Date: January 5, 2024

Response to Comments

Project Name: Undi Commerce Park
 Project File Number: PA 22008
 Review Completion: July 18, 2023

Proposed Buildings for
Undi Commerce Park
 SEPA Plans
 Marysville File #PA22008
 Marysville, WA

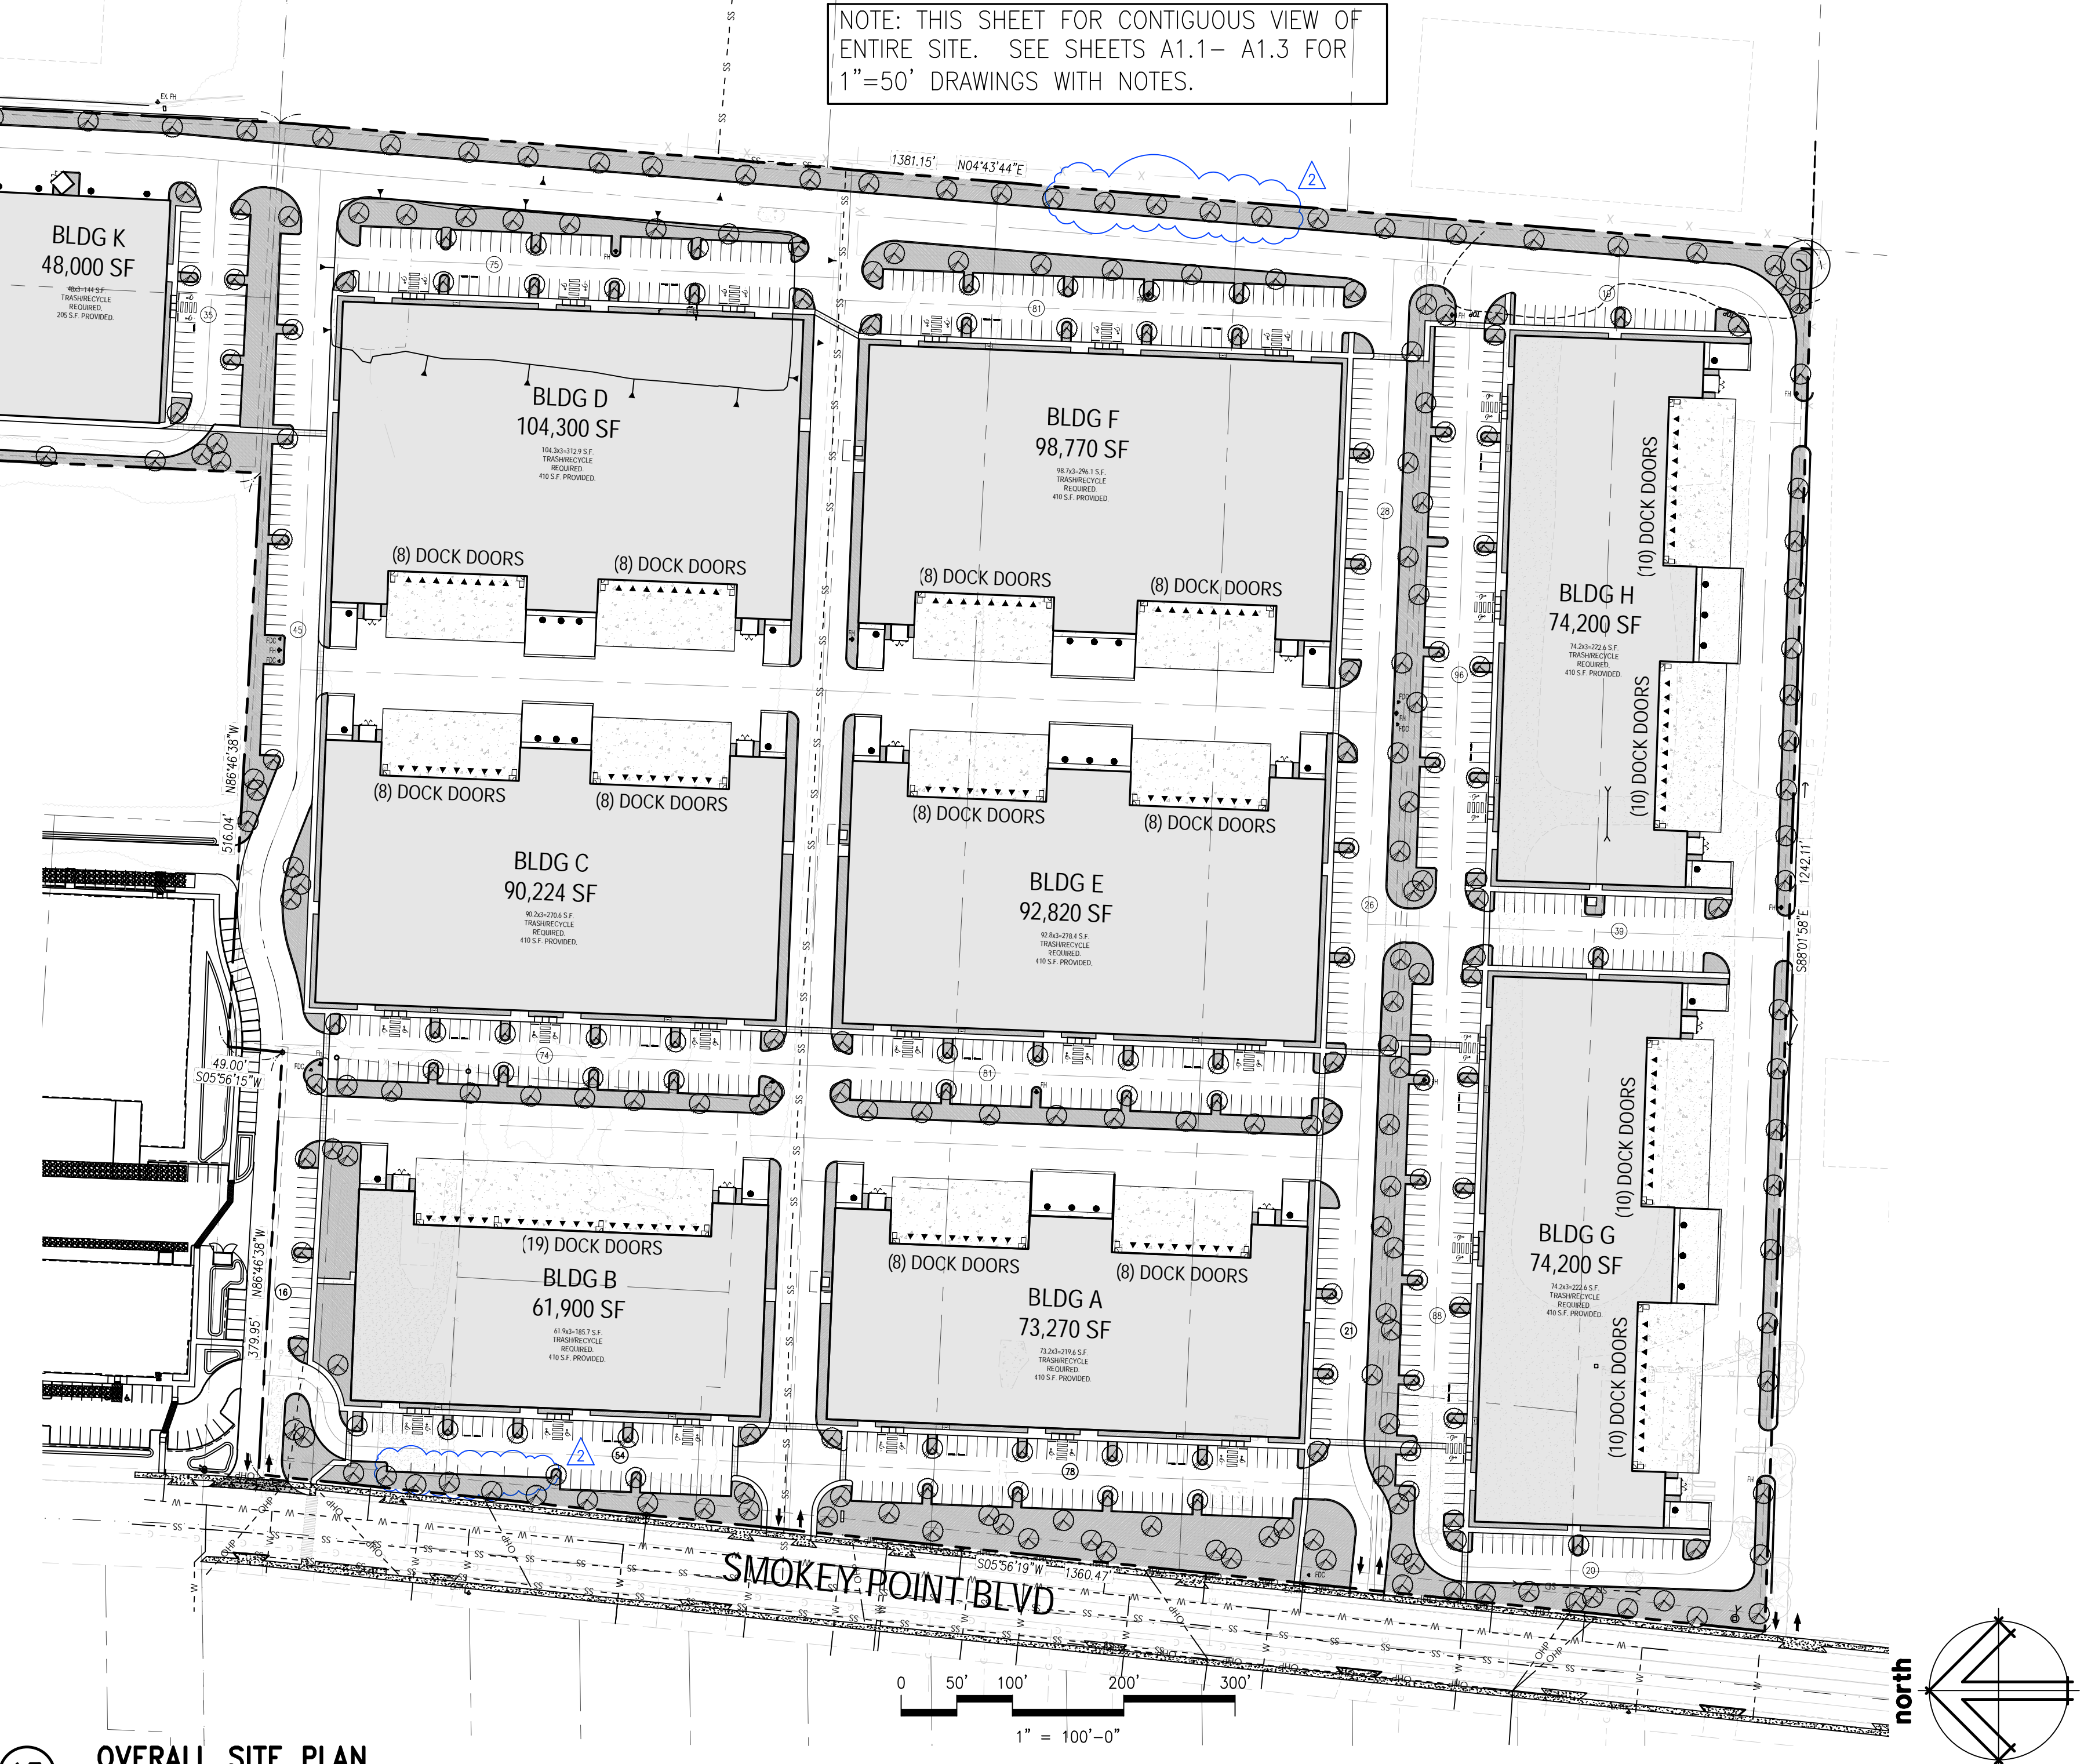
CITY COMMENTS	LAND TECH RESPONSE
Community Development: Reviewer: Chris Holland, Planning Manager	
1. The ARCH Site Plan shall be amended, as follows: <ul style="list-style-type: none"> a. Provide a cover sheet that includes the entire development site, similar to Sheet C1. b. A pedestrian connection will need to be provided from the sidewalk on 152nd Street NE and Building I. 	<ul style="list-style-type: none"> a. See Architectural Plans for Cover Sheet. b. Separated Pedestrian connection added from 152nd St to Building I.
